NSW RURAL FIRE SERVICE

Your reference: SSD-11437498
Our reference: DA20201207004583-EIS & DA
Exhibition-1

**State Significant Development - Electricity Generating Works
Request for comments - exhibited Environmental Impact Statement (EIS)
Broken Hill Battery Energy Storage System 74-84 Pinnacles Place Broken Hill NSW 2880, 58//DP258288**

**FIGURE 1:
PROJECT AREA LAYOUT**

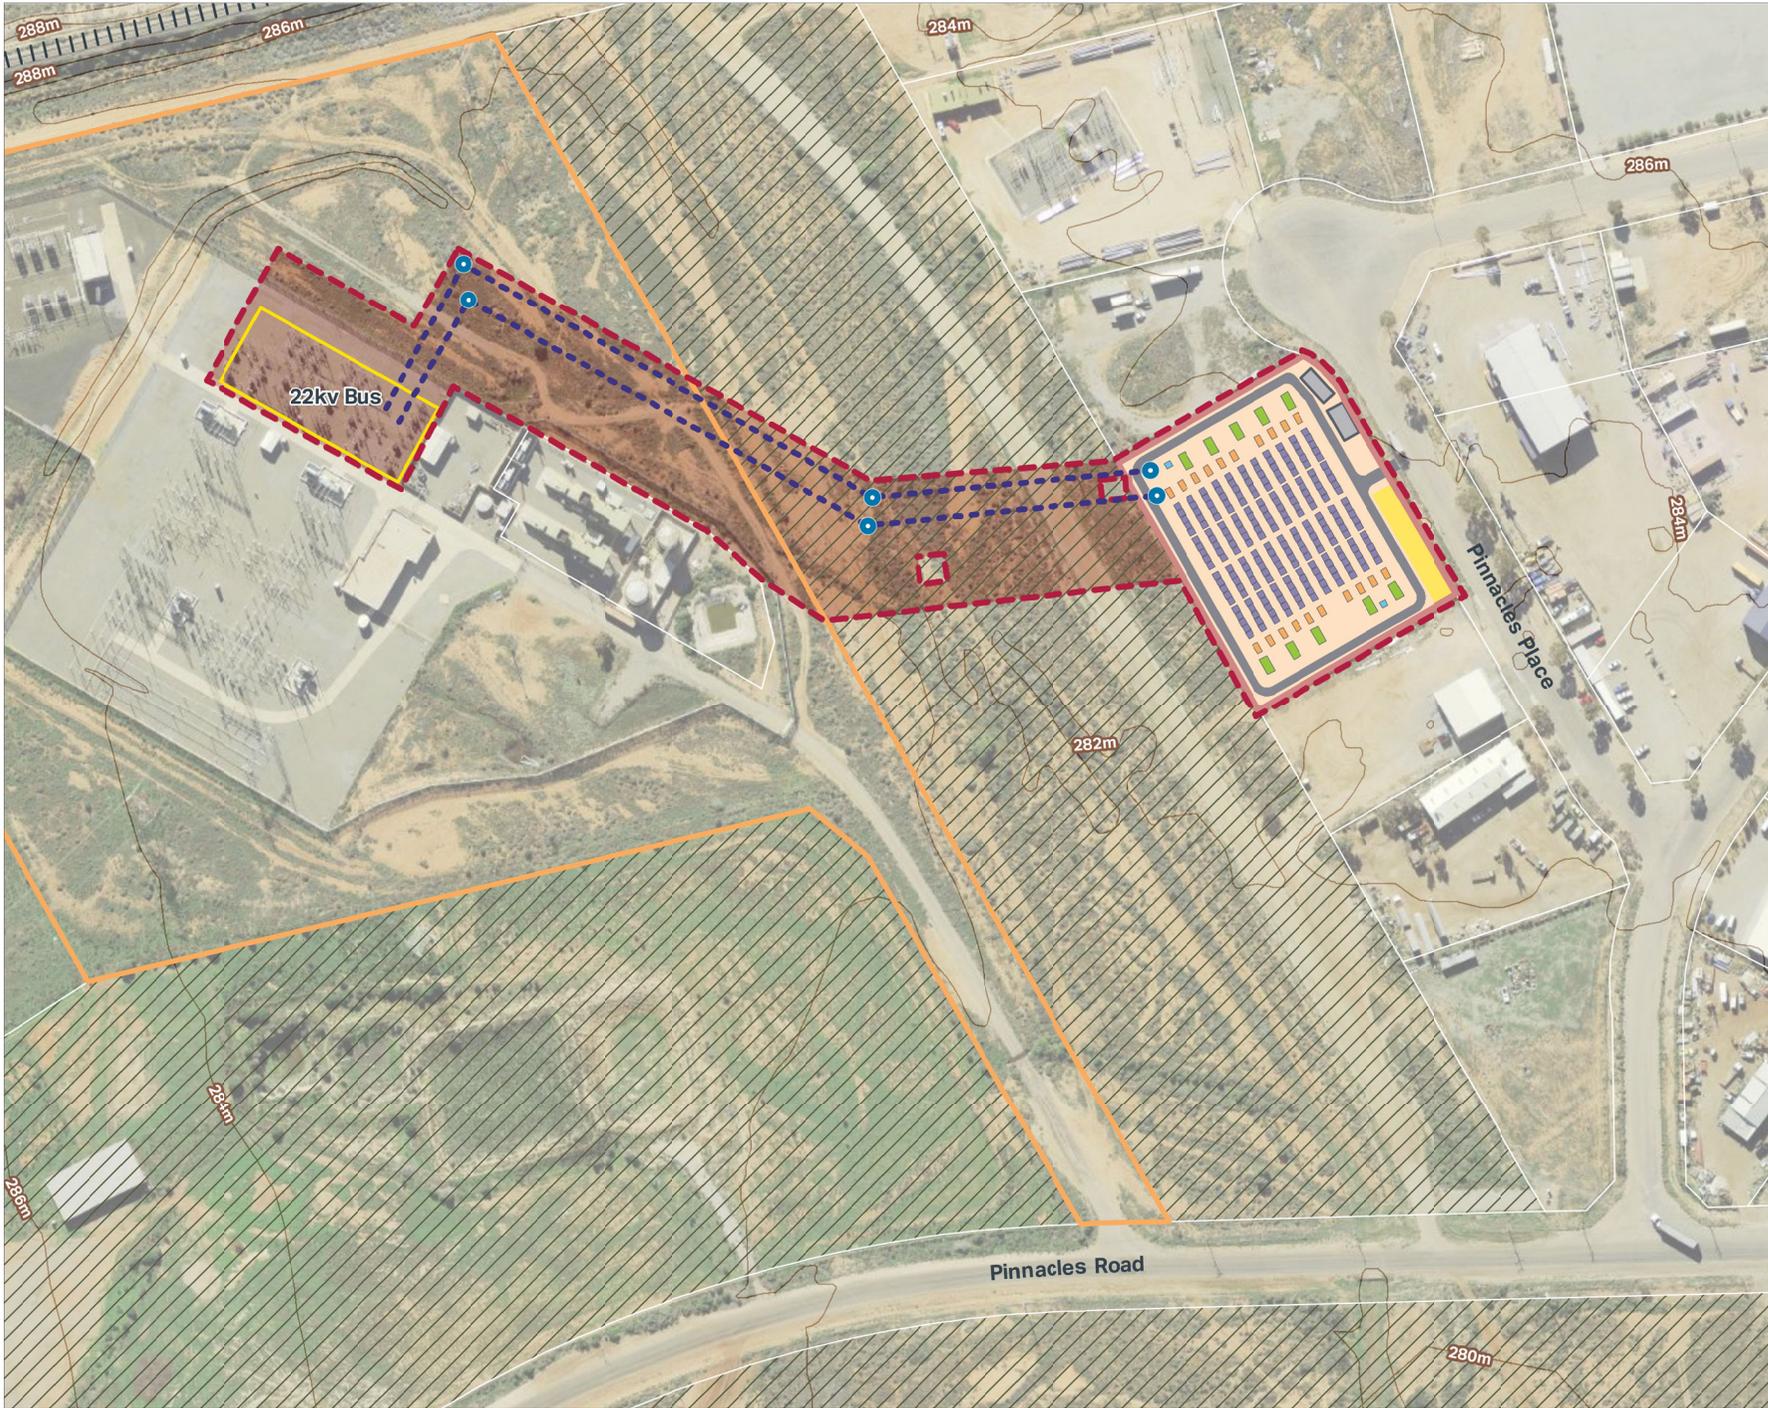
- Such additional matters as required by the Far West office (FMP review and updates).
3. A minimum asset protection zone (APZ) setback of 10.5 metres must be provided between the western boundary of the site (Lot 57 & 58 DP 258288) and the proposed Battery Energy Storage System (BESS).

6. The proposed BESS must be designed and constructed to withstand ember attack and radiant heat up to and including 12.5 kW/m² from a bush fire attack.

8. The proposed 'Access Road' must comply with the following standards for property access roads under Table 7.4a of *Planning for Bush Fire Protection 2019*:

- two-wheel drive, all-weather roads;
- the capacity of road surfaces is sufficient to carry fully loaded firefighting vehicles (up to 23 tonnes);
- minimum 4m carriageway width;
- provide a loop around the BESS;
- have passing bays every 200m that are 20m long by 2m wide, making a minimum trafficable width of 6m, at the passing bay;
- a minimum vertical clearance of 4m to any overhanging obstructions, including tree branches;
- curves have a minimum inner radius of 6m and are minimal in number to allow for rapid access and egress;
- the minimum distance between inner and outer curves is 6m;
- the cross fall is not more than 10 degrees; and
- maximum grades for sealed roads do not exceed 15 degrees and not more than 10 degrees for unsealed roads.
